CITY OF ALBUQUERQUE
 PLANNING DEPARTMENT
 DEVELOPMENT REVIEW BOARD

Project# 1009506

- 13DRB-70758 VACATION OF PUBLIC EASEMENT
- 13DRB-70759 - TEMP DEFR SWDK CONST
- 13DRB-70760 MAJOR - PRELIMINARY PLAT
- 13DRB-70761 SITE DEVELOPMENT PLAN FOR SUBDIVISION
- 13DRB-70762 VACATION OF PUBLIC RIGHT-OF-WAY

BOHANNAN HUSTON INC agents for PULTE HOMES OF NEW MEXICO request the referenced/ above actions for Lots 14-19, **VOLCANO CLIFFS UNIT 6 (tbka MONTECITO WEST UNIT 2)** zoned SU-2 VOLCANO CLIFFS RURAL RESIDENTIAL (VCRR), located on ALBERICOQUE PL NW between VISTA VIEJA NW and SCENIC RD NW containing approximately 16.54 acres. (D-9)

Plat for
Montecito West Unit 1
 Being Comprised of
Lots 15-21, Volcano Cliffs Subdivision Unit 6
 Together with a Portion of Vacated Retablo Road NW
 and Albericoque Place NW Rights-of-Way
 City of Albuquerque
 Bernalillo County, New Mexico
 June 2014

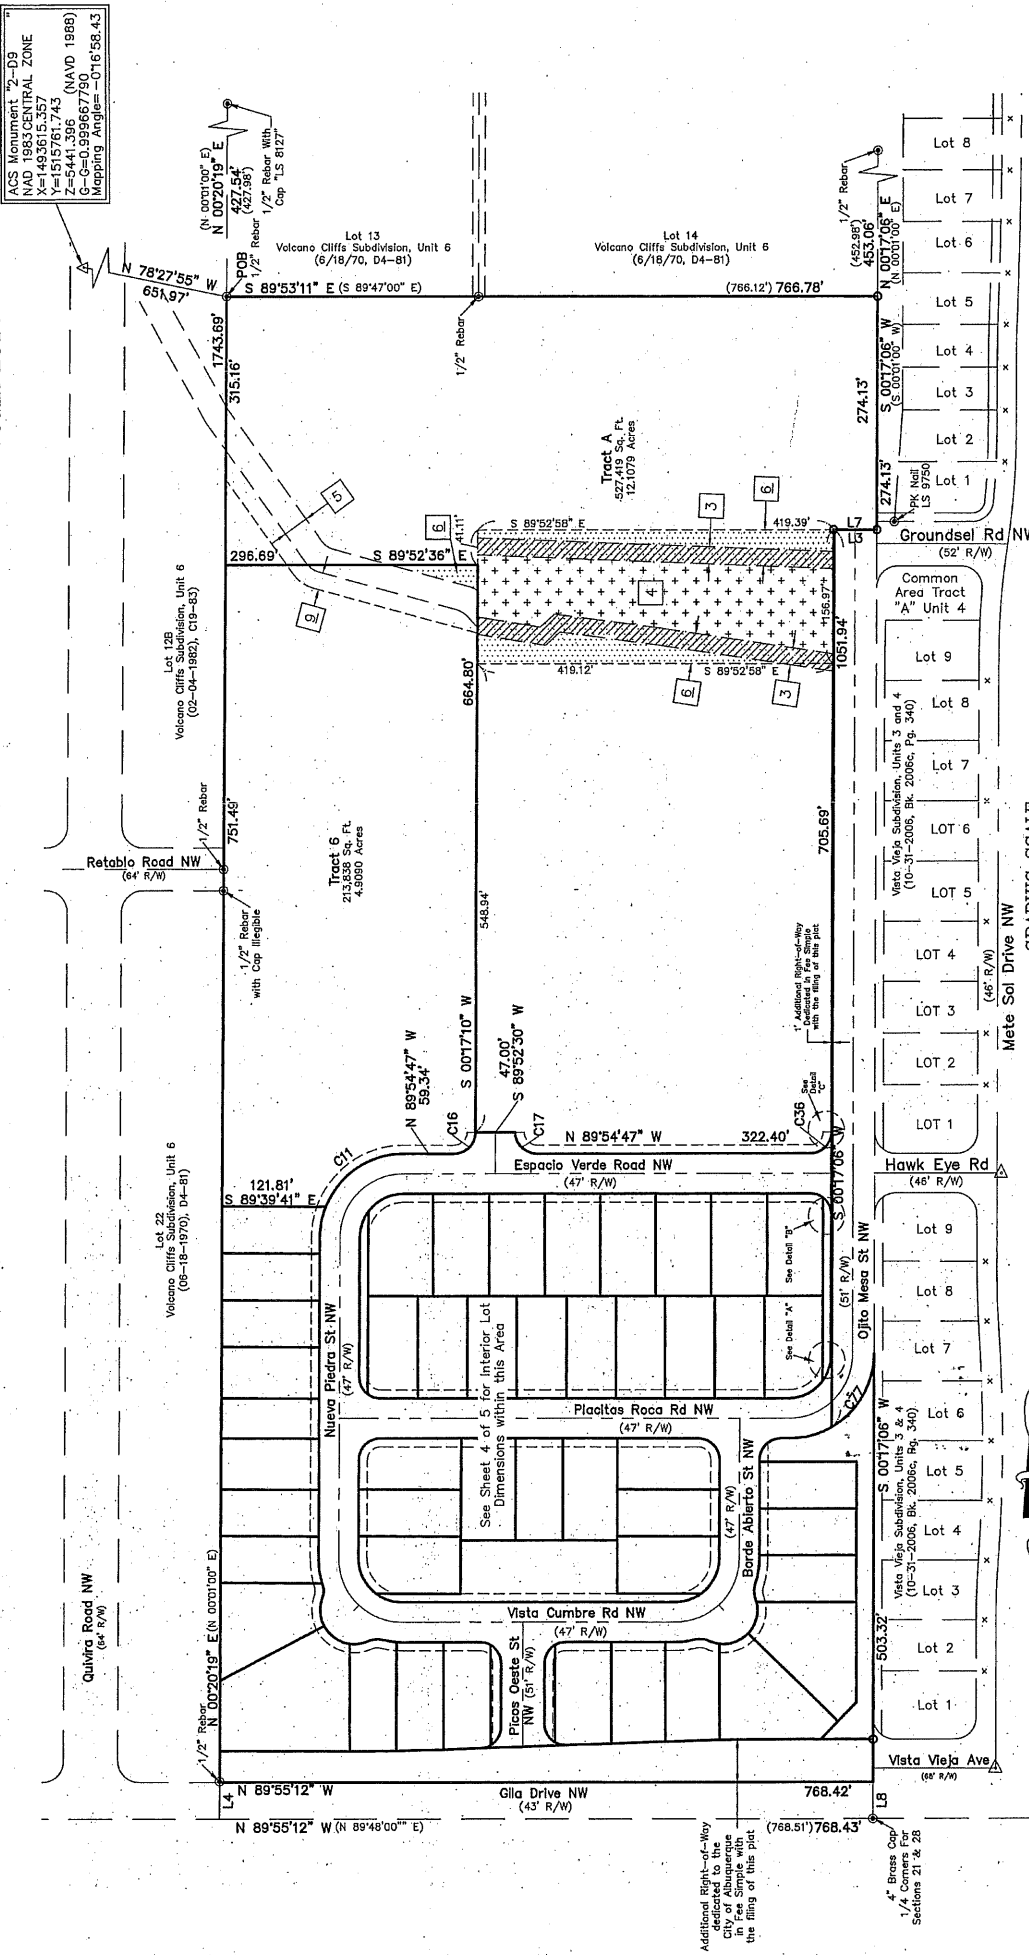
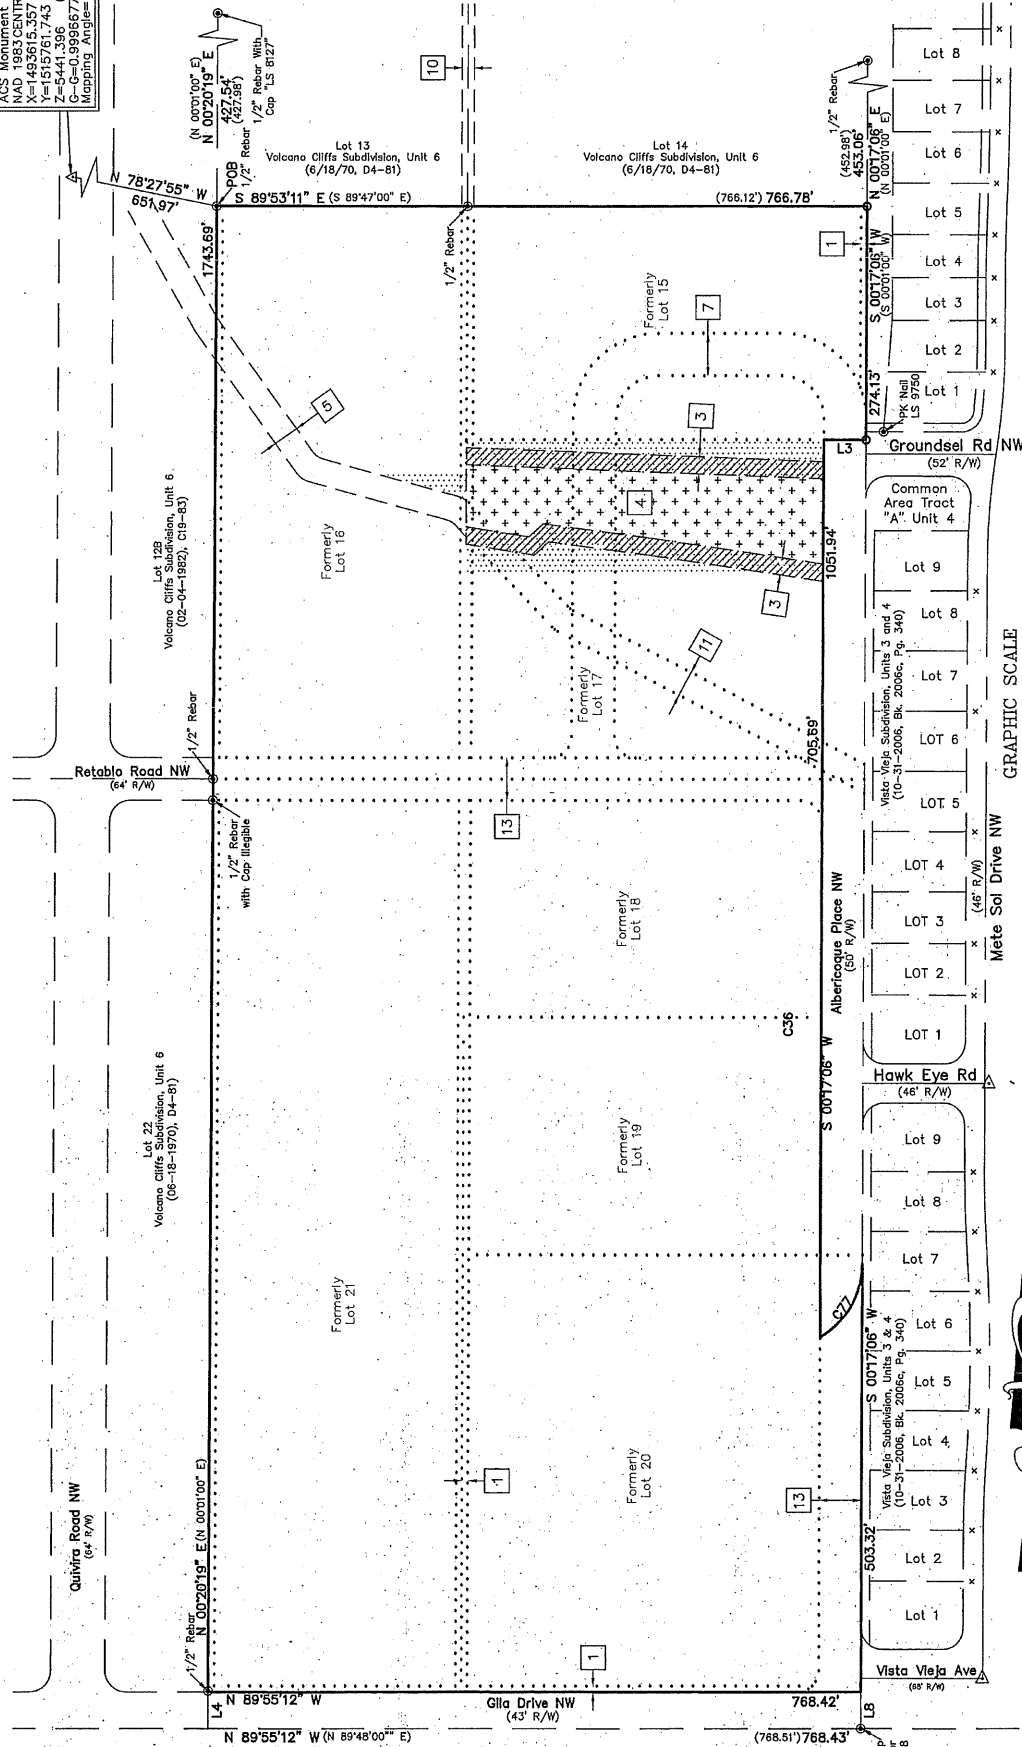
- a. The vacation texture on Tract 1 obscures the note regarding “Common Area Tract... for Unit4) and could be moved to Unit 4 of Vista Vieja so it would be legible. Tract A label on Lot 17 is confusing.

- b. Parks & Recreation’s Open Space Division requests that the Parceled Commons Areas Tracts 5 & 6 be dedicated to the City to be managed as public Open Space by the Open Space Division. Please change General Notes #7 to reflect this change.

- c. The Public Open Space will need to be fenced prior to construction of adjacent infrastructure and residential lots to prevent damage to existing vegetation.

- d. Please change all references to Private Commons Areas (PCA) as the name has been changed to Parceled Common Areas (PCA) within Private Commons Development (PCD). Per the Ordinance, Parceled Common Areas can be Public or Privately owned and maintained. In this request, the Parceled Commons Areas shall be Public Parceled Commons Areas.

- e. Legend shows "Existing fence line" but it is not shown on the Preliminary Plat as existing along the south boundary of the Unit south side of Gila Road, please show this existing fence.
- f. Provide note in General Notes as to the responsibility of the HOA to maintain the 2 HOA tracts.
- g. Line weights in the Legend are difficult to differentiate on the Plat.
